From: Craig NOEL [REDACTED]
Sent: 30 May 2022 15:43
To: Anita Gardner <Anita.Gardner@arun.gov.uk>
Cc: Julie ODONOGHUE [REDACTED] Helen MCCARTHY
[REDACTED]
Subject: FW: [EXTERNAL] RE: A/45/22/PL - Rustington Golf Course, Rustington #

Subject: [EXTERNAL] RE: A/45/22/PL - Rustington Golf Course, Rustington

Cc: NOEL Craig [REDACTED]
Subject: A/45/22/PL - Rustington Golf Course, Rustington

Scale 1:500 @ A1	Date APRIL 2021	Drawn TDM	Checked NB
Drawing No A351-PLN-1-4005			Revision A

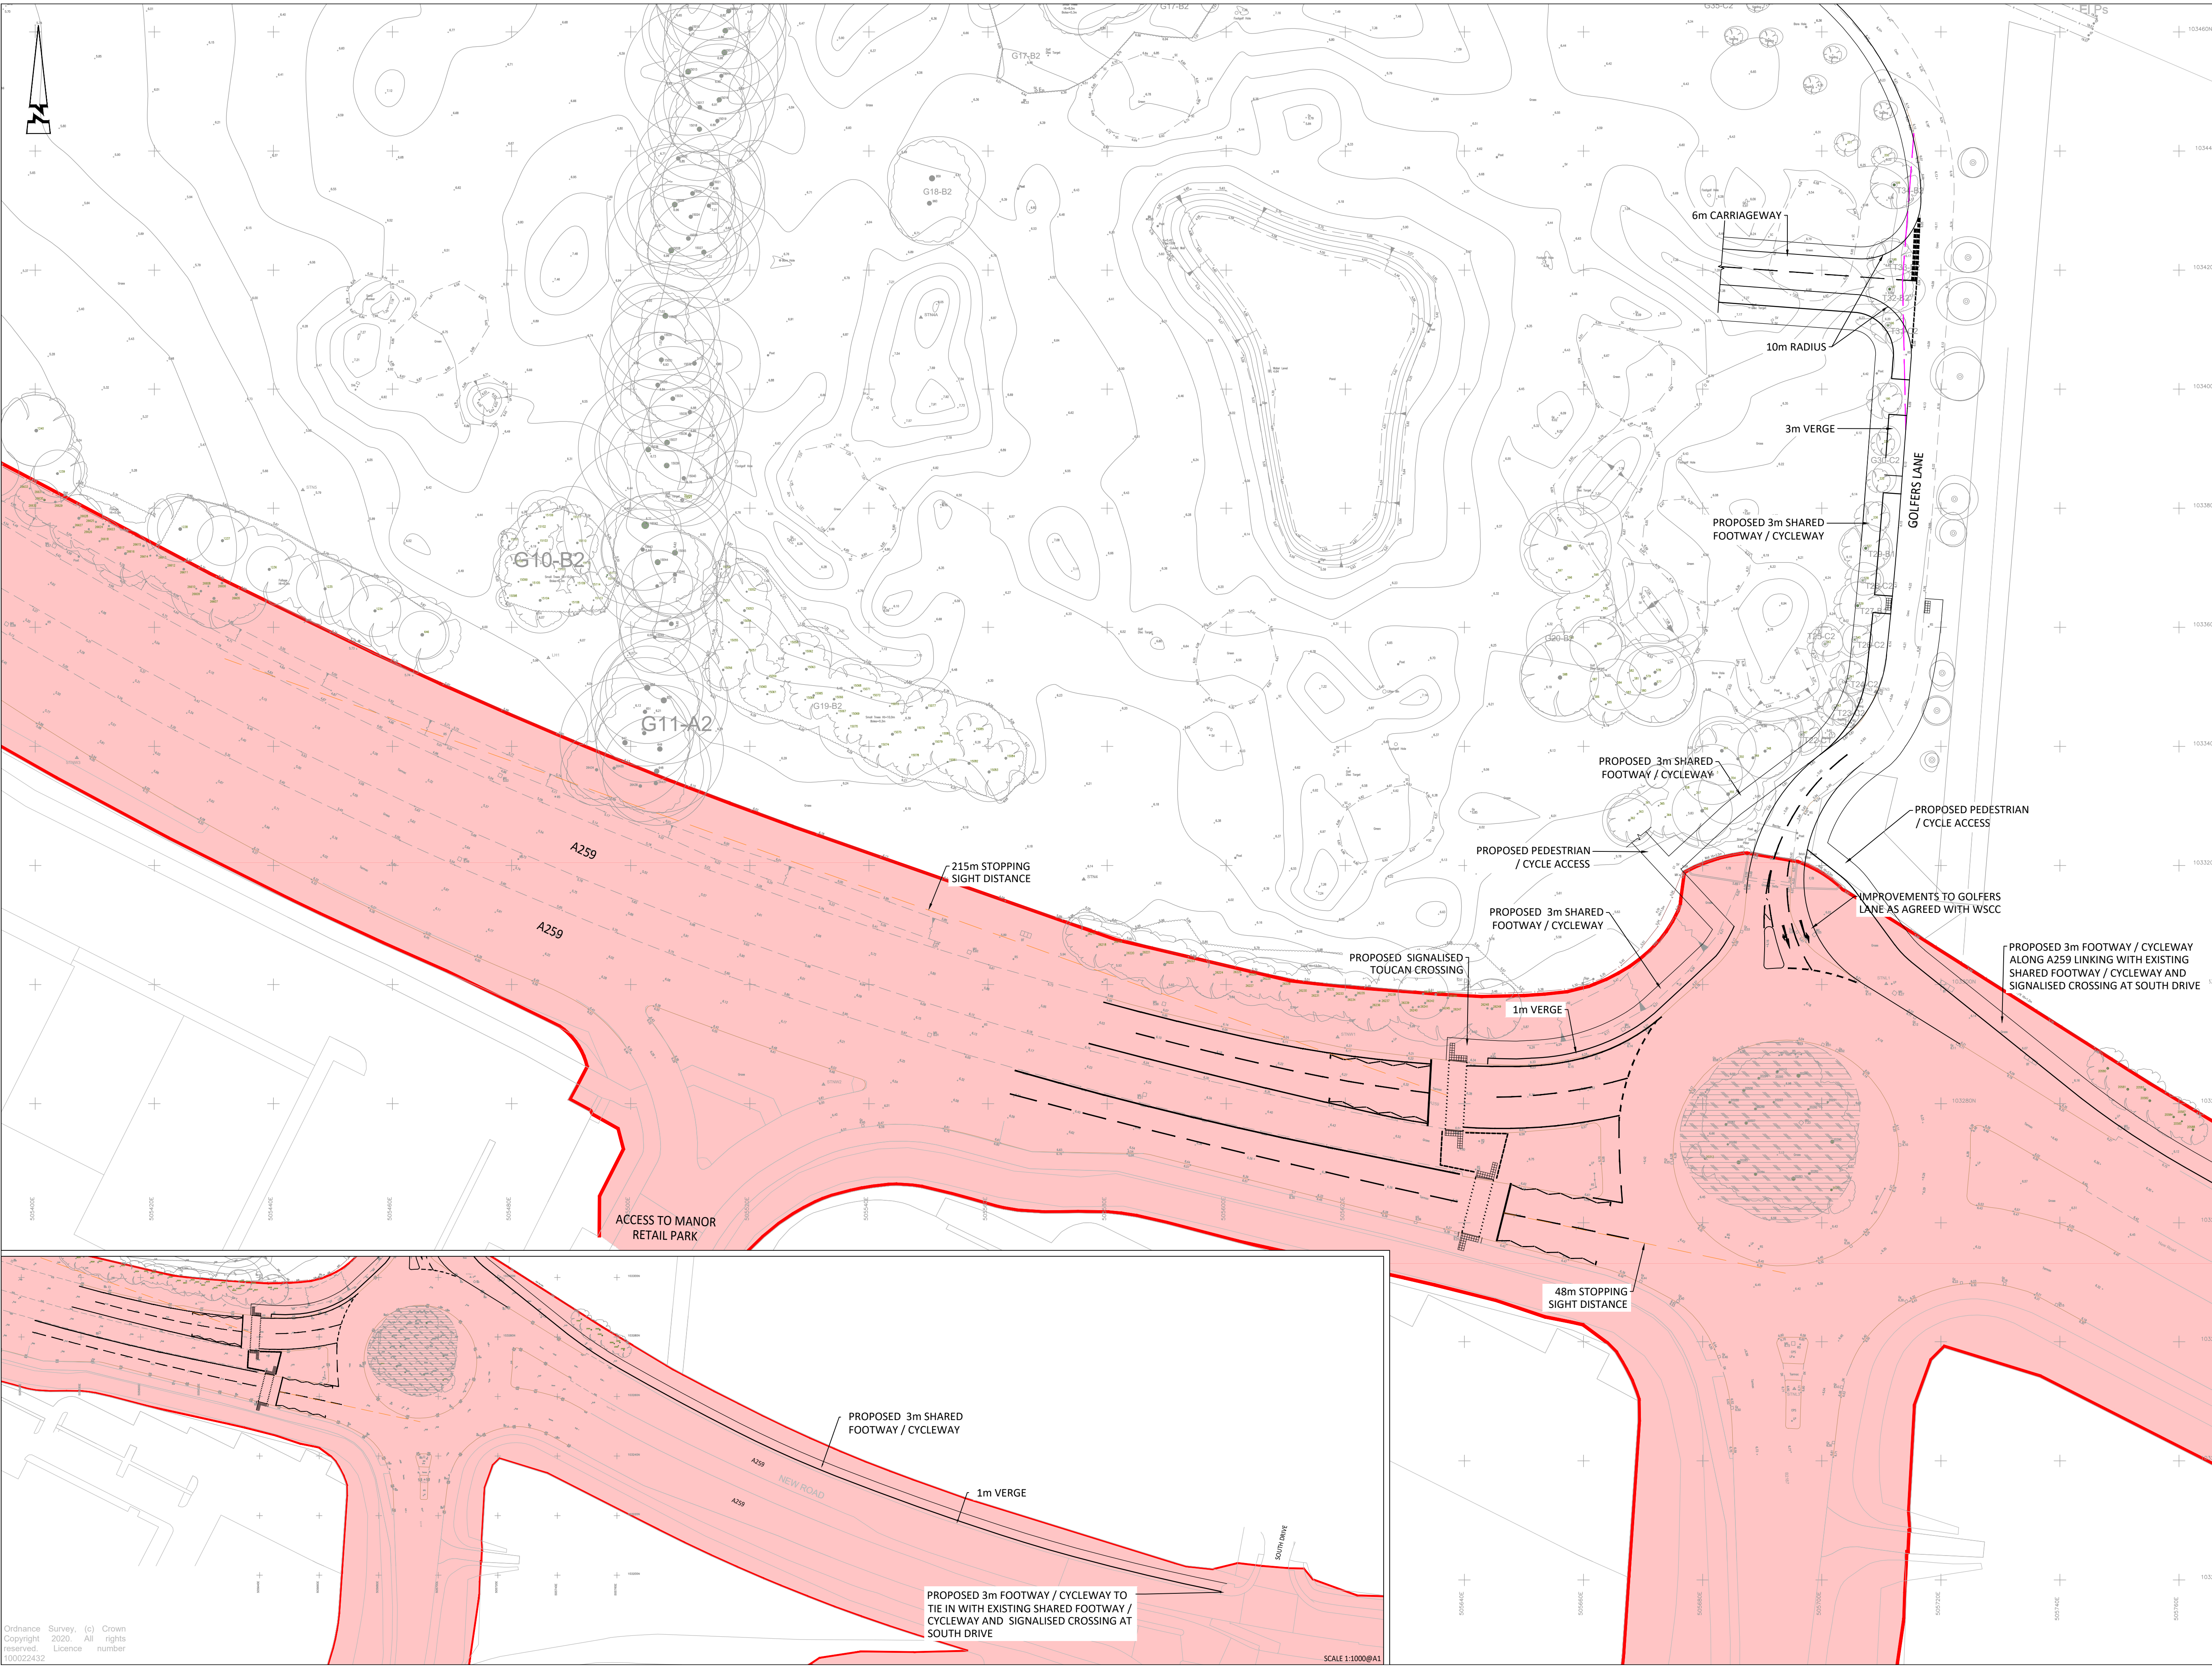
I think it's far to say that the main outstanding matter is the A259 Toucan crossing. I recognise the comment within your response that the site is not reliant on this crossing. I don't necessarily disagree although a scheme without the crossing would need to road safety audited. The crossing could provide a far more convenient arrangement for pedestrians travelling southwards to Rustington compared with using the crossing at the Rustington Retail Park. I'd hope you'd therefore agree that there is merit in exploring to its conclusion the possibility of installing the crossing.

In terms of progressing the crossing, ordinarily the design and any Departures from Standard should first be resolved, and then for the RSA problems to be considered. Problem 2.1 within the RSA refers to the location of the crossing though and this problem doesn't appear to be fully addressed within the RSA response. I would ask that this problem and the auditors recommendation be revisited, and if necessary the design adjusted before the DfS is applied for; my concern otherwise is that the DfS is signed off only for the design to then have to be revised to suit the RSA, triggering the need to assess the DfS again.

On the basis that problem 2.1 is addressed, the attached form would need to be completed for the DfS. The departure would be for the crossing to be situated on a high speed (where 85th percentiles are 50+mph) road. It would be for you to identify any other design departures based on the appropriate standards. Once received, the DfS will then be assessed. Please can you ensure all supporting information is included with the DfS submission (e.g. speed data).
